From: [REDACTED]
Sent: 26 March 2018 14:36
To: Simon Davis
Cc: Mark Coates; Nat King-Smith (MHA); Phil Brophy
Subject: RE: BR/35/18/PL Gravits Lane

Subject: BR/35/18/PL Gravits Lane

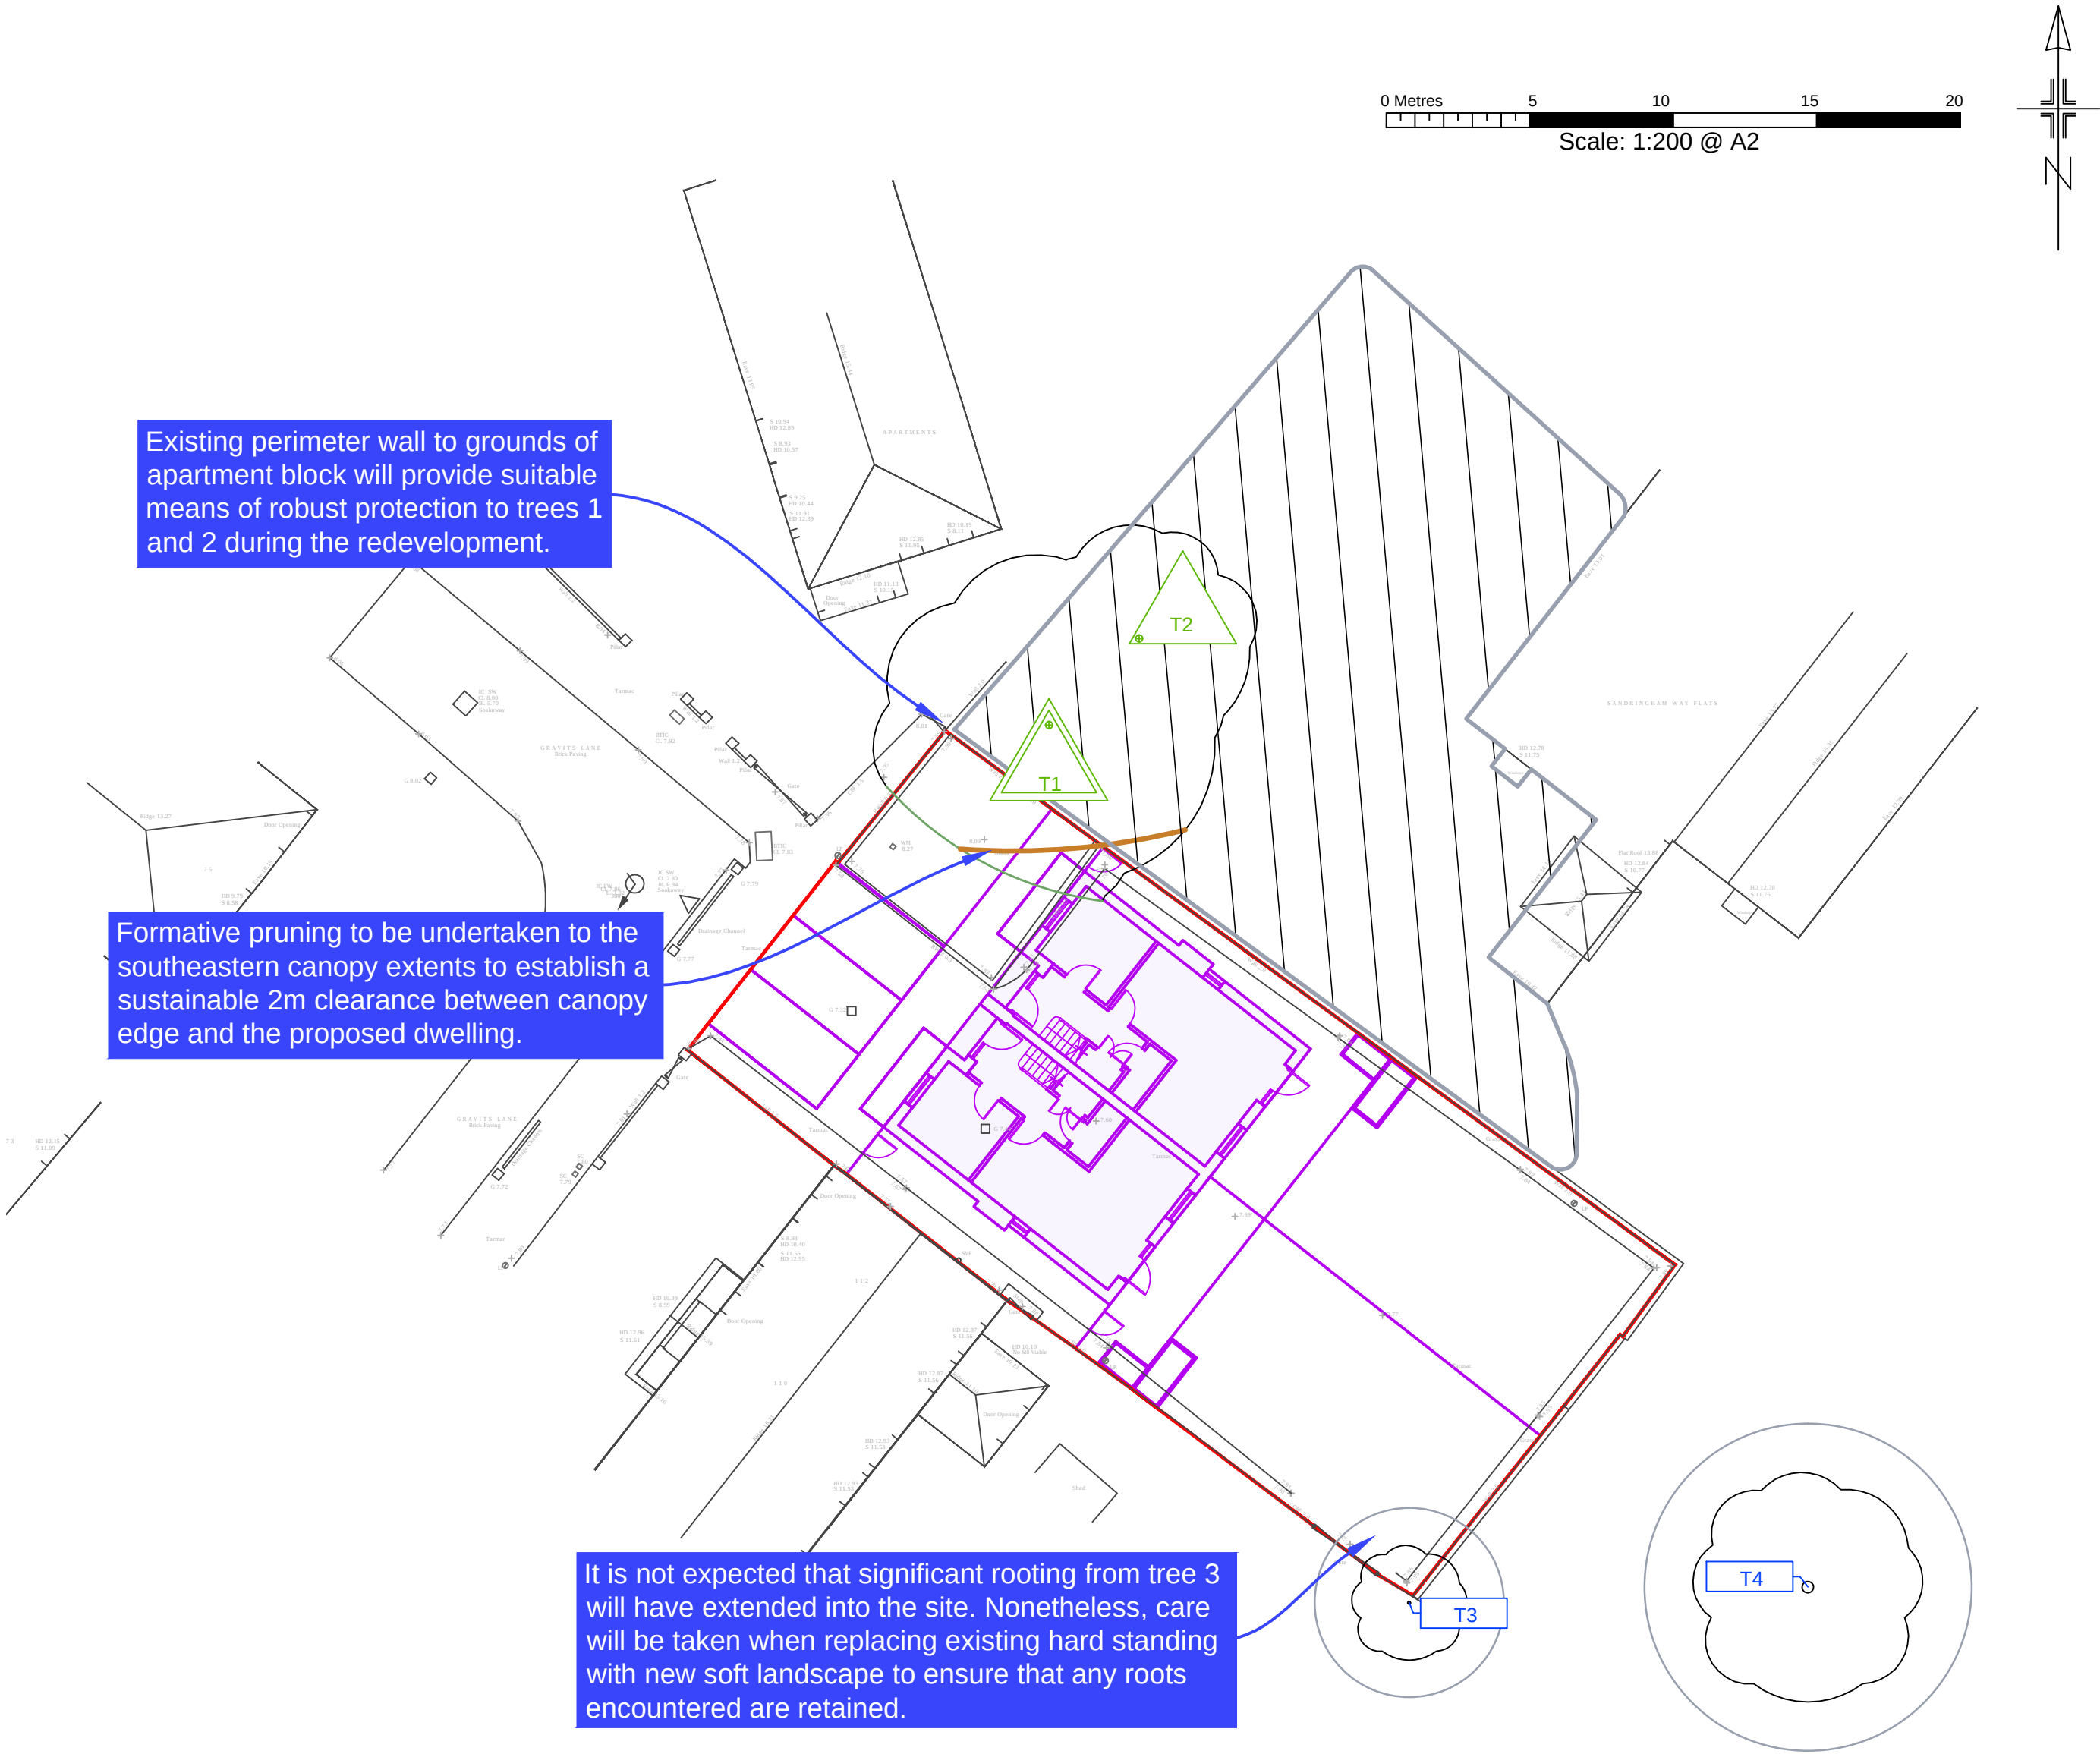
- 1 -It is positive to see that the tree officer is happy with the categorisation of the existing trees.
- 2 - Given the nature of onsite conditions and anticipated restriction to tree rooting extents, it was determined that the most appropriate way to set out the root protection areas for trees 1 and 2 was graphically on the plan (via a heavy grey line – see key annotation), rather than a base numeric within the schedule. My assessment of the retaining wall and ground levels is that these factors will have restricted any significant rooting extents from trees 1 and 2 from the area and depth of proposed development. In order to secure this opinion in light of the stated concern of the LPAs tree advisor I would suggest that a trial excavation is undertaken at the base of the retaining wall to confirm the depth of its foundations and demonstrate the absence of roots from trees 1 and 2. The area within the site that is soft verge (see photo below – and blue shaded area) appears to have been the historic location of a large holm oak (– now removed) and that roots from this tree (still present but non functional and slowly decaying) will have accounted for the observed raising and modification of the existing hard surfacing within the site rather than the cause being that of trees 1 and 2.

3 – If need be (and if disturbance of the car park area is not a problem) then further trial excavation could be undertaken along the foundation line of the proposed building to confirm existing ground conditions and root absence.
